Application No: BE/37/21/HH
Site Address: 19 South Way Bersted PO21 5HB
Description of works: Removal of 3 No existing lean-to structures, erection of single storey side & rear extension, loft conversion to form new 2nd floor with roof alterations to form gable end with rear dormer projection & detached outbuilding to be used as annexe to existing dwelling.

Thank you for your internet representation made on 18th April 2021 which has been recorded as an objection with the comments as follows:

1st floor plan
1 : 50

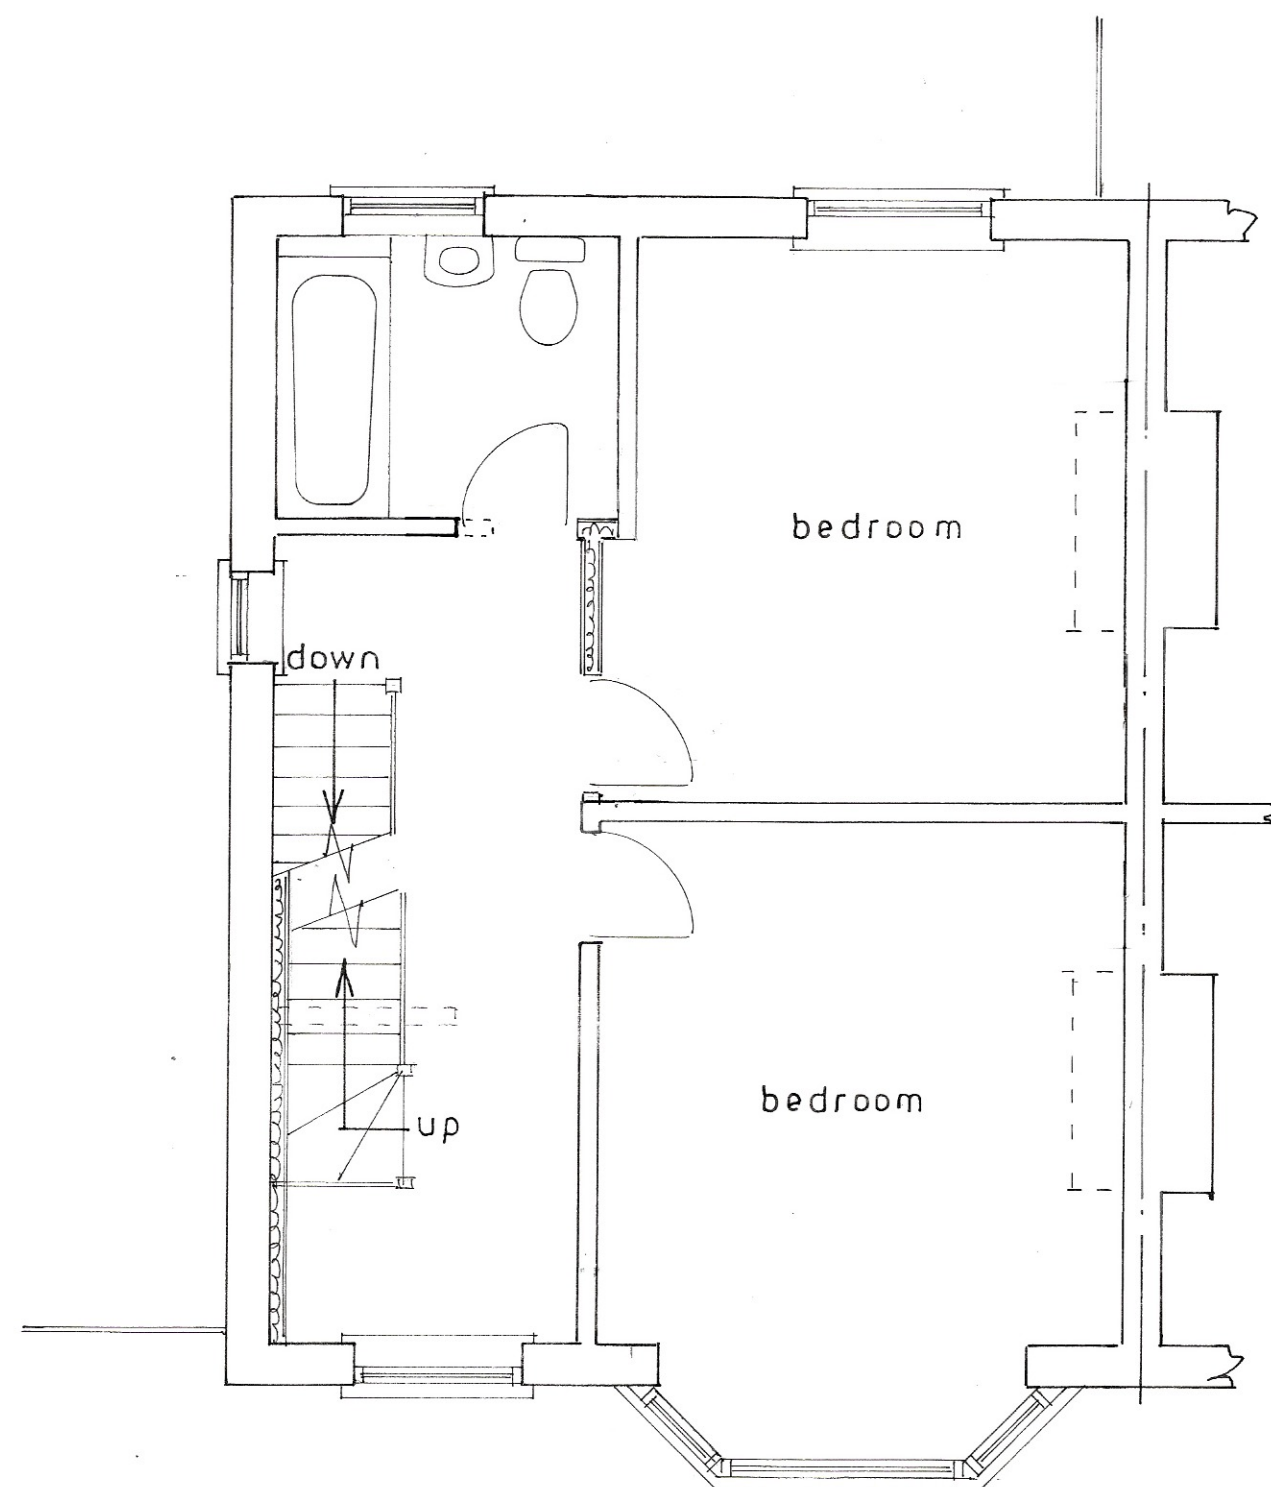
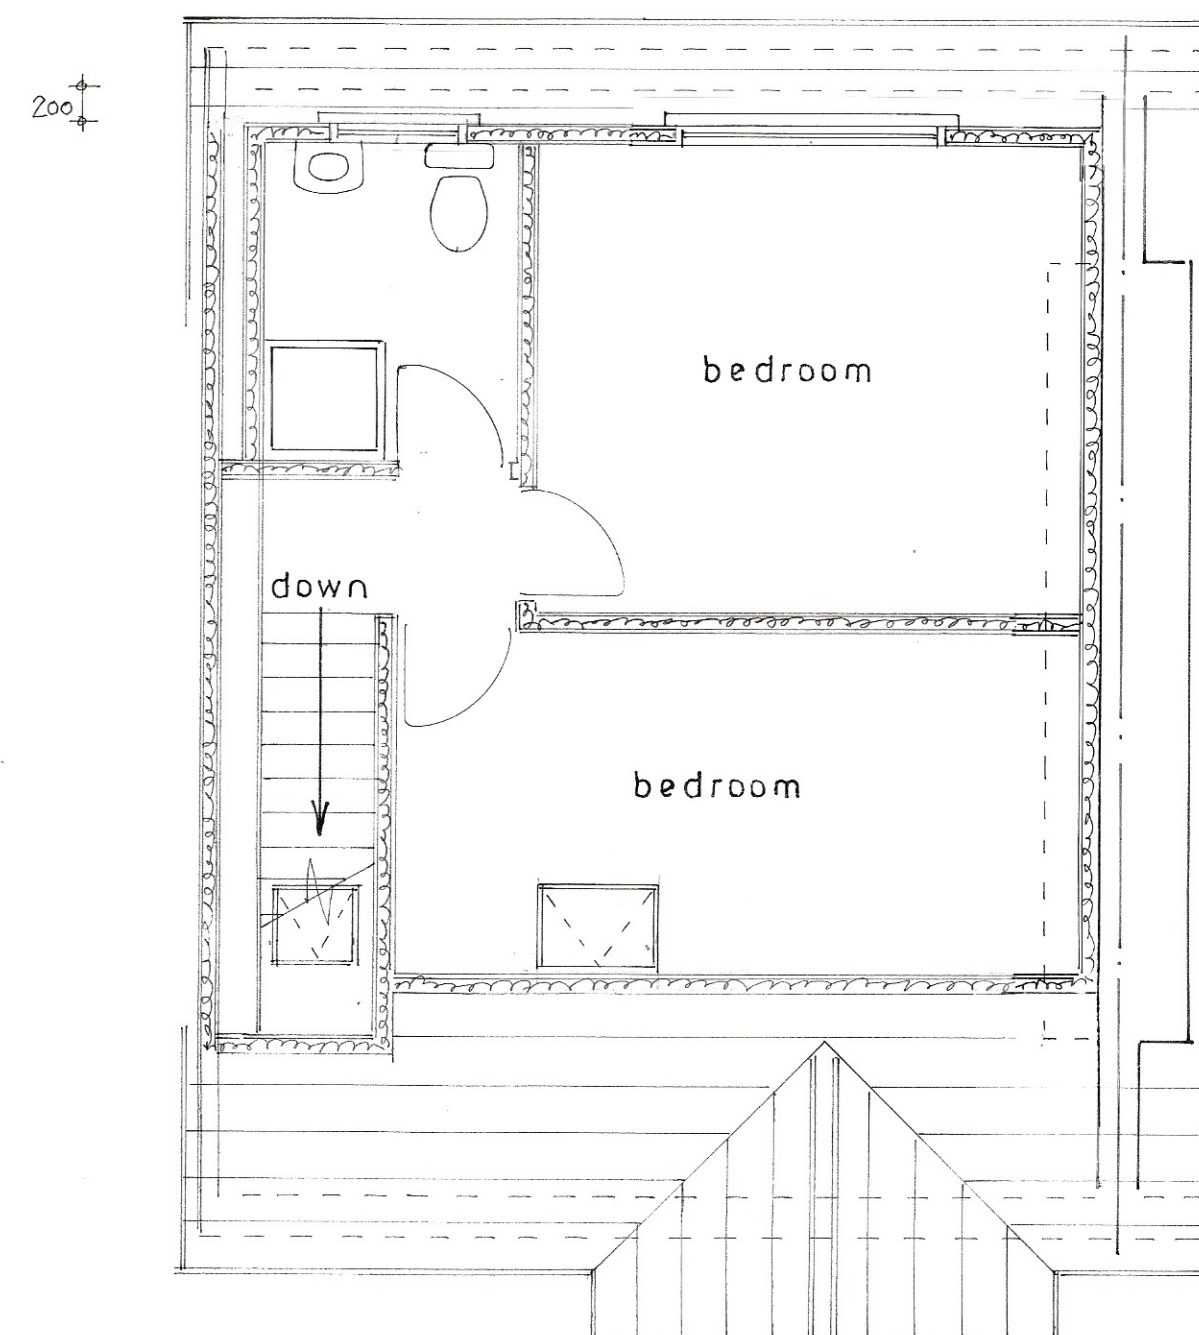
1) There are no kitchen facilities shown on the plans and the applicants agent has confirmed that there are not any plans to install kitchen facilities.

PROPOSED DETACHED OUTBUILDING AT 19, SOUTH WAY, BOGNOR REGIS
FOR MR.O.SAPOZHNYK.

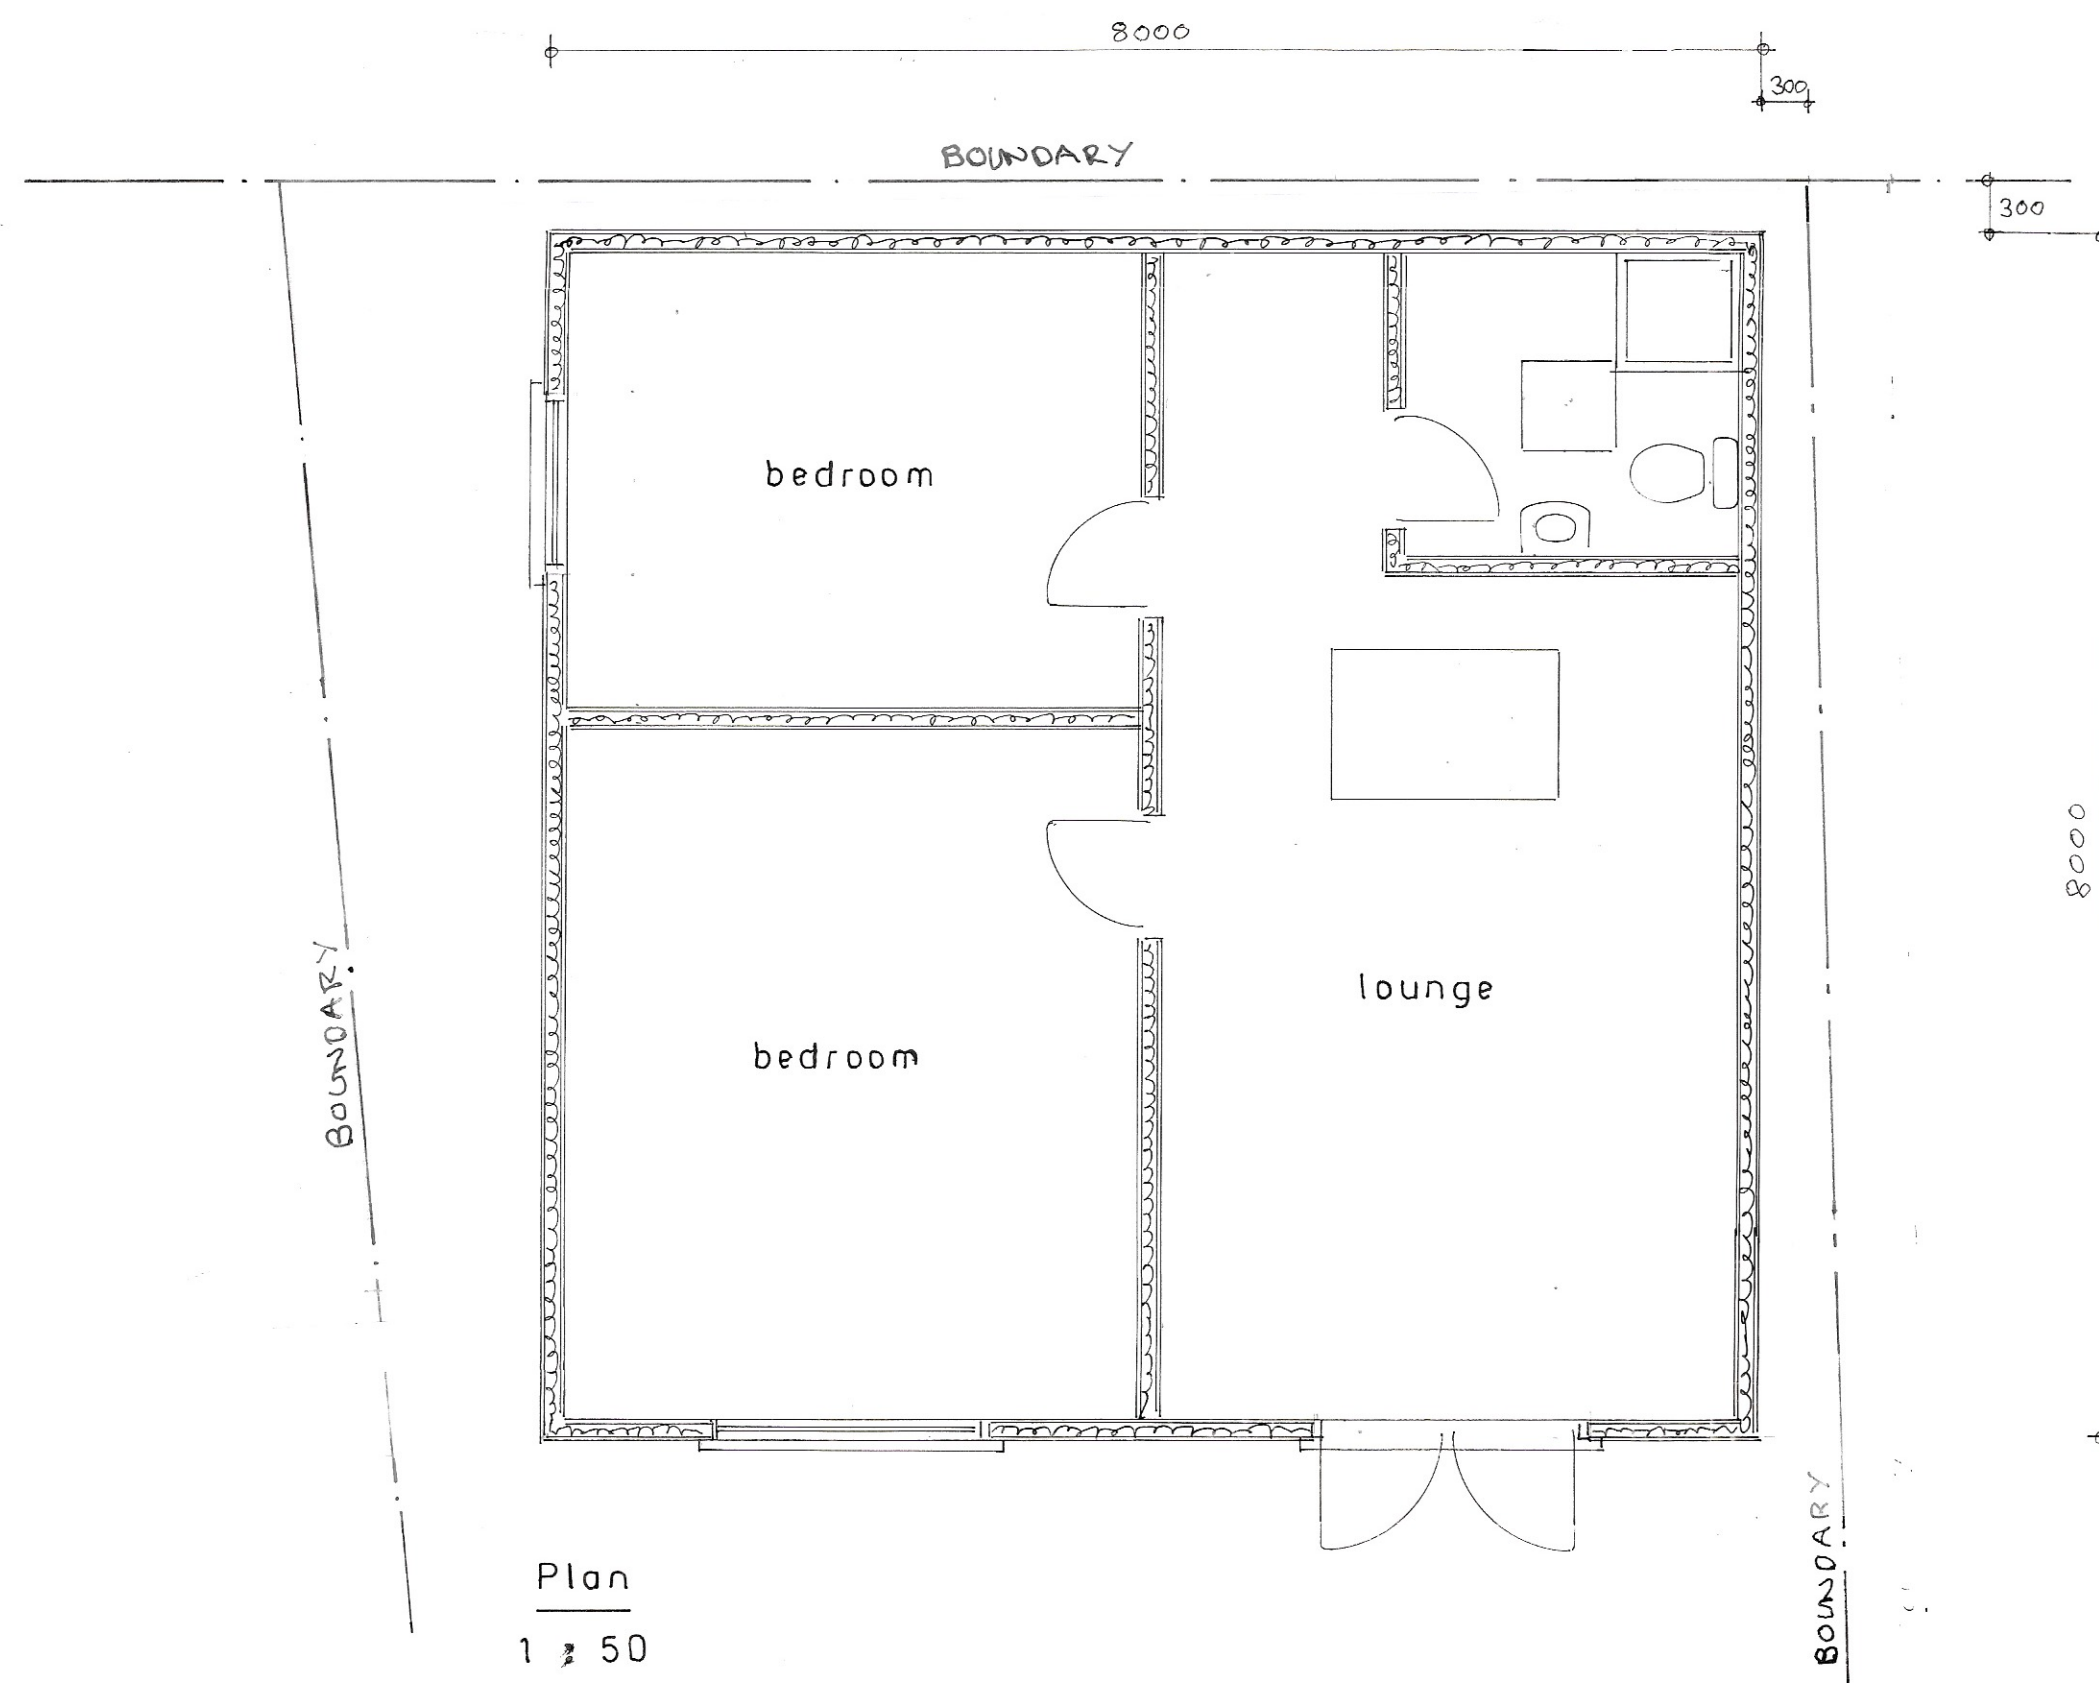
5) It is unclear from the plans submitted how access would be gained to the annexe.
